PLAN REVIEW SHEET

Date: June 23, 2023

Petition #: 2023-028

SHEET NUMBER  
**RZ-1**

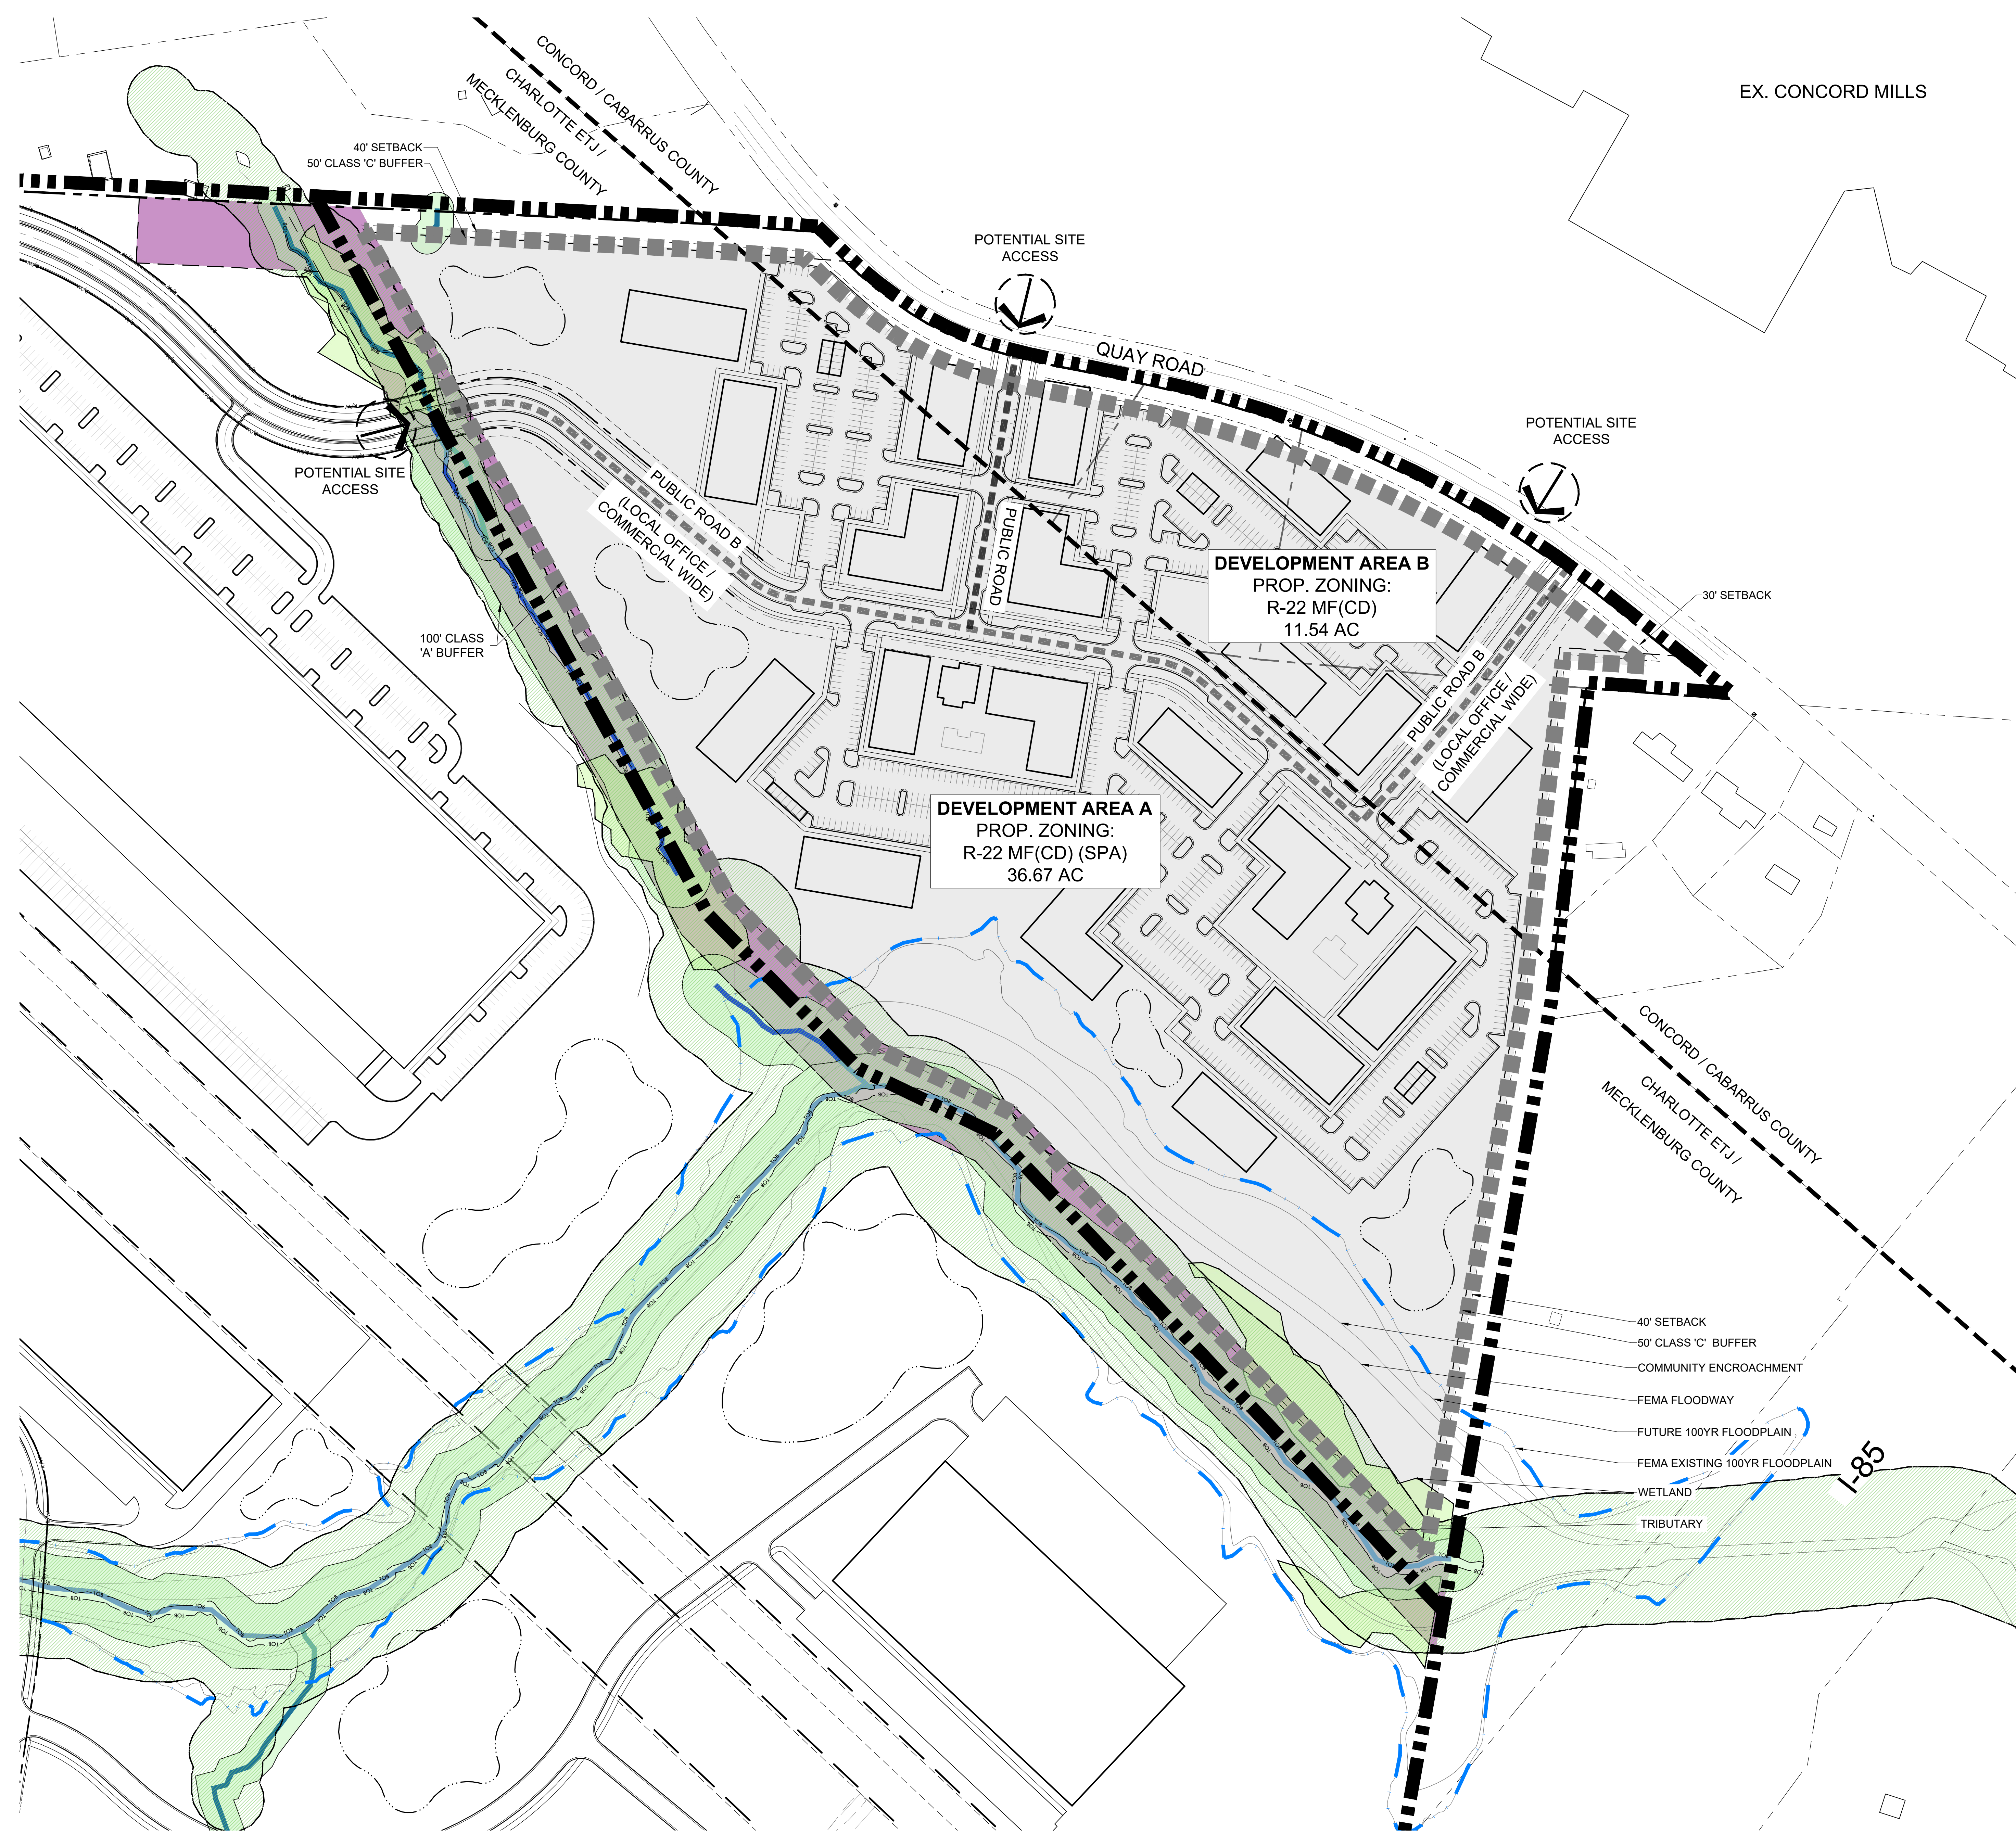
The site is located on Quay Road along CATS bus route #54. CATS requests the provision of a pedestrian walkway to access the mall parking lot to improve proximity to the existing bus stop on the mall property for the future residents of the development.
